Application No: R/31/26/HH

Recommendation Report for Planning Permission for Works or Extension to a Dwelling

LOCATION: 15 Evelyn Avenue
Rustington
BN16 2EJ

PROPOSAL: Single storey front porch and rear extension to replace the existing conservatory, proposed hip to gable extensions, a rear dormer, roof lights and side windows with obscure glass.

Rev.	Notes	Date
 NAT DESIGN ARCHITECTURAL SERVICES M: 07599199759 E: info@nat-design.co.uk www.nat-design.co.uk		
Project		
15 Evelyn Avenue, Rustington, BN16 2EJ		
Drawing		
Proposed Site & Roof Plans		
Drawn By NSE		Scale as shown
Date Feb 2026		Revision
Drawing No. 2027 -DPA - 02

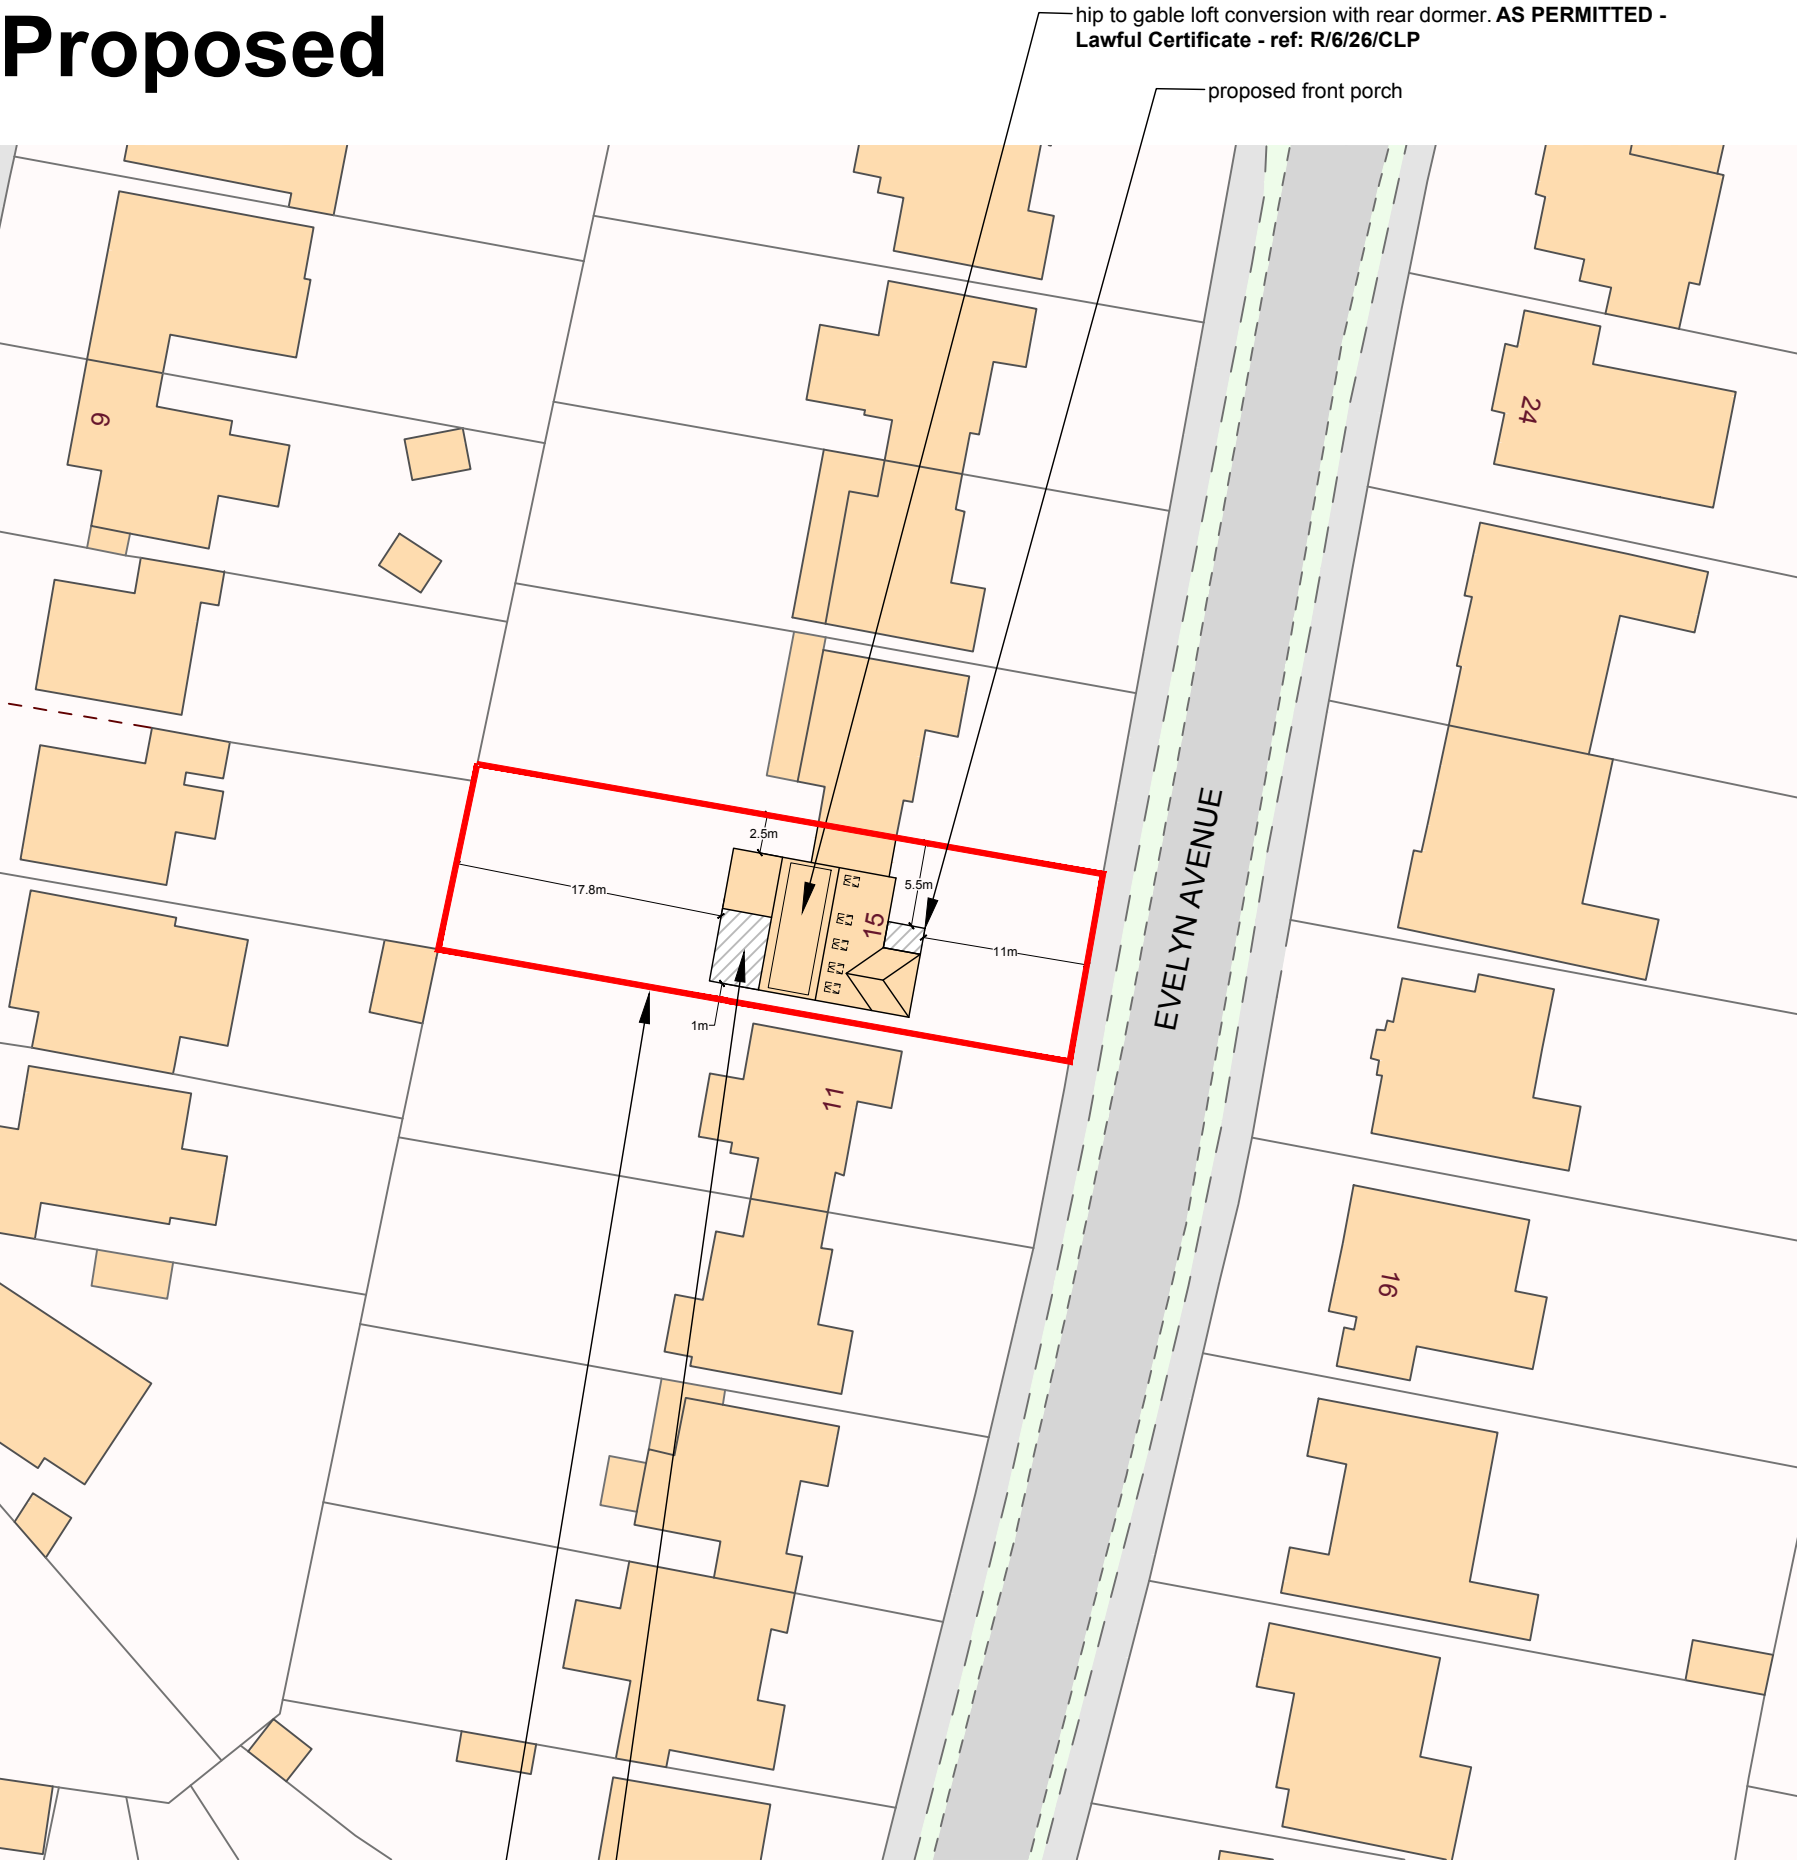
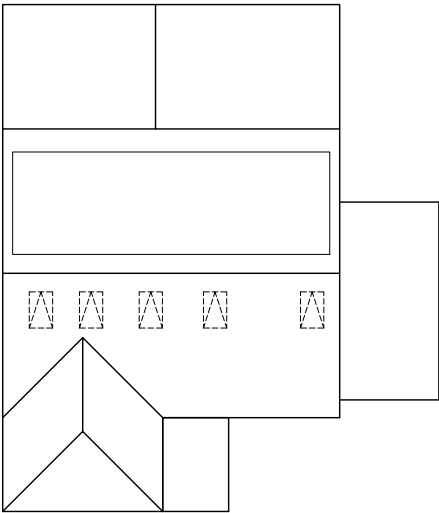
The hip to gable roof extensions fall under permitted development as they would not exceed 50 cubic metres of additional roof space. The dormer proposed under this application would exceed permitted development in terms of its volume to 71.7 cubic metres (total enlargement inclusive of the hip to gable extensions). It is noted that a smaller rear dormer could be achieved under permitted development.

The single storey rear extension would replace an existing conservatory and would result in an increase in depth by 0.3m to 3.3m from the existing structure, with a width of 4m. The flat roof would have a height of 3m and an eaves height of 2.65m. The proposal would sympathetically integrate with an existing rear extension to the northern aspect of the rear elevation. Sufficient garden depth of 17.8m would be

The proposal would remove the chimney and construct hip to gable roof extensions, resulting in the creation of gable ends to the northern and southern flank elevations. The maximum ridge height would remain unchanged at approximately 5.9m. The hip to gable extensions would extend the width of the ridge line by approximately 8.2m to 9.5m and would be visible within the street scene, similar to the pitched roofs of 12 and 14 Evelyn Avenue. Whilst it is noted that there are limited examples of gabled roofs within the street scene, it is noted that there are two examples opposite the application site to the east, and it has been demonstrated under application reference R/6/26/CLP that the roof could be altered in the same way under permitted development. As such, the proposed hip to gable roof extensions would not result in demonstrable harm to the visual amenity of the host dwelling or street scene.

Rev.	Notes	Date
 M: 07599199759 E: info@nat-design.co.uk www.nat-design.co.uk		
Project 15 Evelyn Avenue, Rustington, BN16 2EJ		
Drawing Proposed Floor Plans		
Drawn By NSE		Scale as shown
Date Feb 2026		Revision
Drawing No. 2027 -DPA - 04

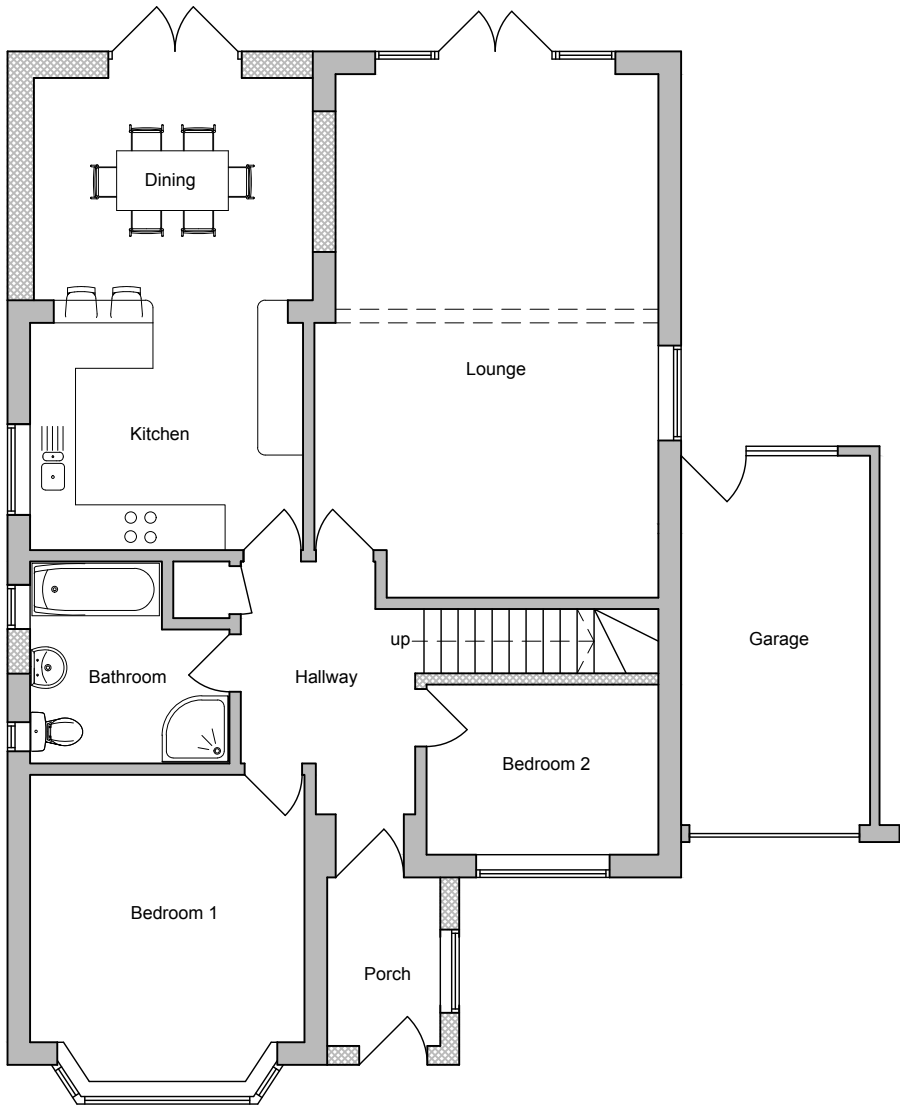
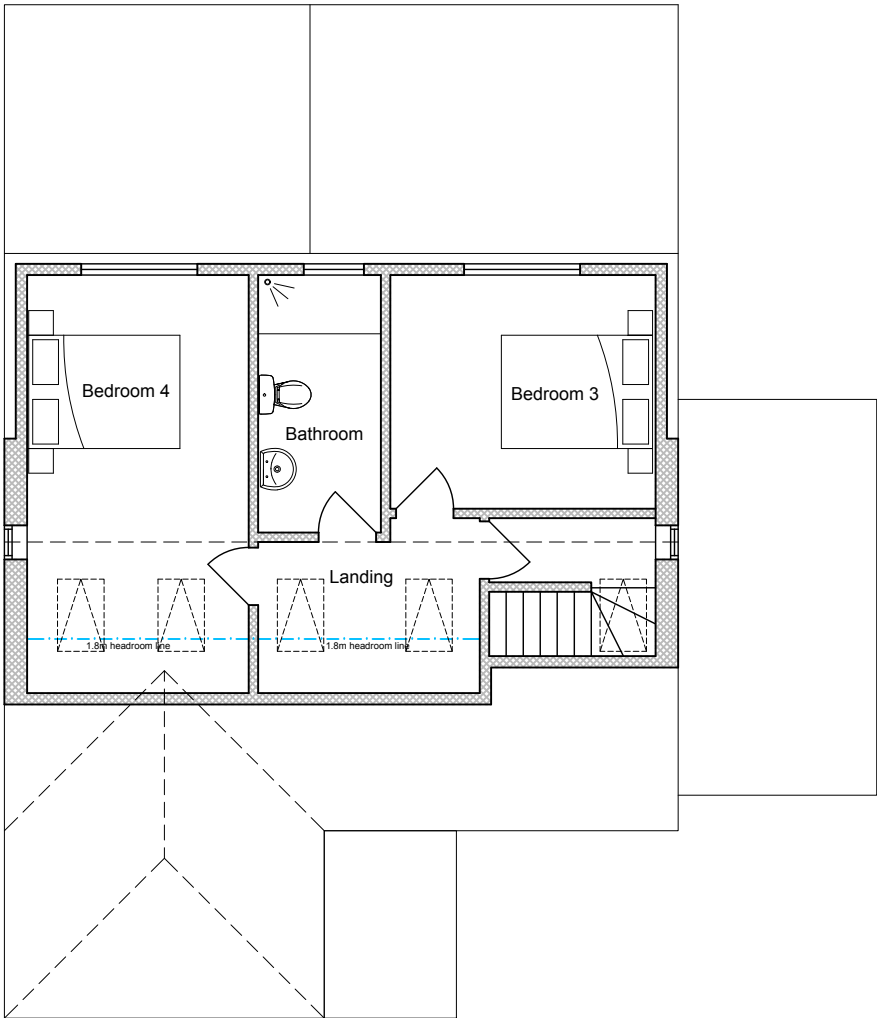
Five rooflights are proposed within the front roof slope of the host dwelling, serving the proposed loft accommodation. The rooflights would be a size and scale which could be constructed under permitted development. The number of rooflights would be proportionate and would not result in harm to visual

The proposal would include the insertion of five rooflights within the front roof slope of the host dwelling. Given the separation distance maintained between the rooflights and the neighbouring properties to the east, the proposed rooflights would not result in unacceptable overlooking. A window is proposed at first floor level within the northern and southern flank elevations of the host dwelling. It is noted that the applicant proposes these windows to be fitted with obscured glazing. However, given the siting of these windows, level with the roof lines of neighbouring properties, and that these windows are small in size, the proposed windows would not result in unacceptable overlooking and as such, it is not reasonable to attach a condition to require these windows to remain obscurely glazed in perpetuity.

Rev	Notes	Date
 M: 07599199759 E: info@nat-design.co.uk www.nat-design.co.uk		
Project:		
15 Evelyn Avenue Rustington BN16 2EJ		
Drawing:		
Proposed Elevations		
Drawn by NSE		Scale as shown
Date Feb 2026		Revision
Drawing		
2027 - DPA - 06

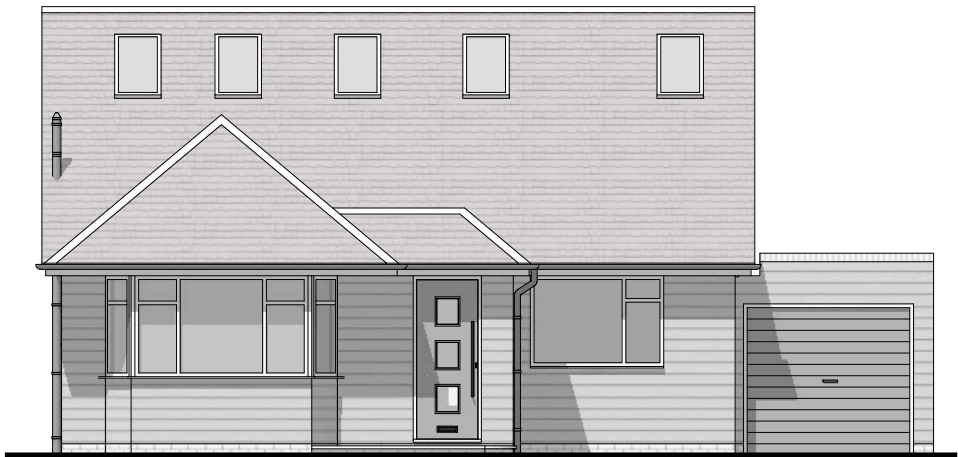
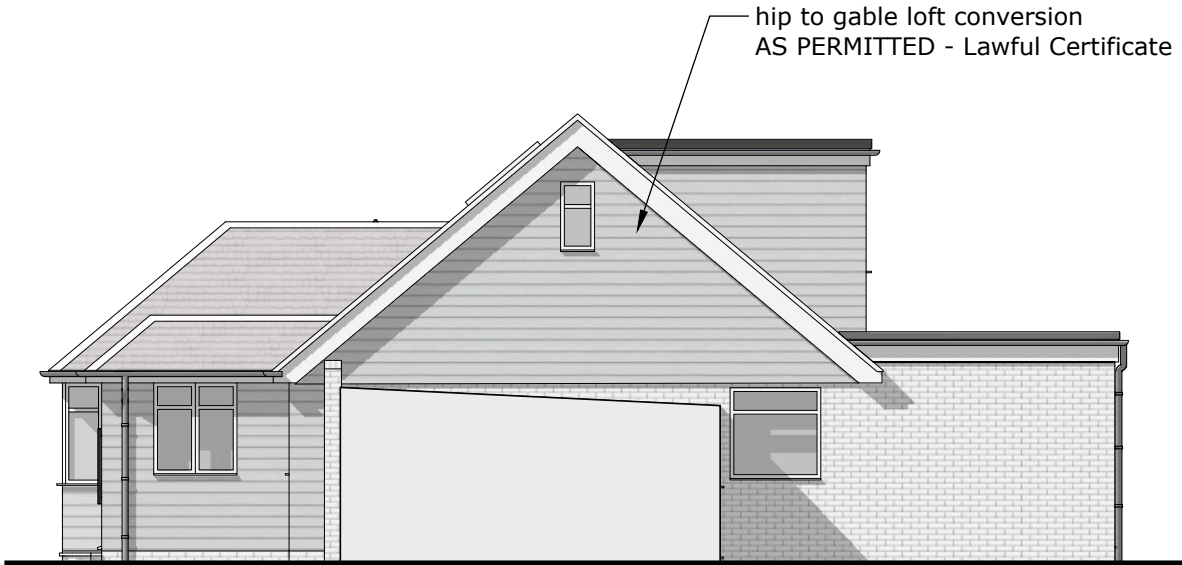
The proposed roof alterations include the construction of a rear dormer with a width of 8.5m and a depth of 3.5m. The dormer would have a flat roof height of 2.5m. The dormer would be larger than that in R/6/26/CLP which had a height of 2.3m, a width of 4.3m and depth of 2.8m.

Whilst the proposed rear dormer would not strictly comply with the ADG or RNP policy 2 and would not be a subservient addition within the rear roof slope, given the siting of the dormer to the rear roof slope of the dwelling, that a dormer of a similar scale and massing could be constructed under permitted development and that there are some large rear dormers within the wider context of the application site, including at number 11 Shirley Close and 31 Evelyn Avenue, the proposed rear dormer would not result in demonstrable harm to visual amenity and is acceptable in this instance.

On the northern flank of the rear (west) elevation, fenestration at ground level would be a four-casement door whilst on the southern flank there would be a two-casement door. At first floor level the proposed fenestration would be two three-casement and one two-casement windows set within the proposed rear dormer. The proposed fenestration would be finished to match the existing and would be proportionate in scale and number.

The proposed single storey extensions would be finished with brick to match the existing and the dormer and gable ends would be finished in tile hanging to match the existing roof tiles. The flat roof elements to the rear extension and dormer would be finished in GRP and the roof tiles to the new front porch would match the existing. The use of matching materials would ensure that the proposed extensions integrate cohesively with the host dwelling, and the proposal is in accordance with ALP policy D DM4.

The applicant submitted amended plans during the course of this application to remove the originally proposed cladding. The proposed extensions and alterations are now proposed to be finished in external materials to match the existing dwelling.
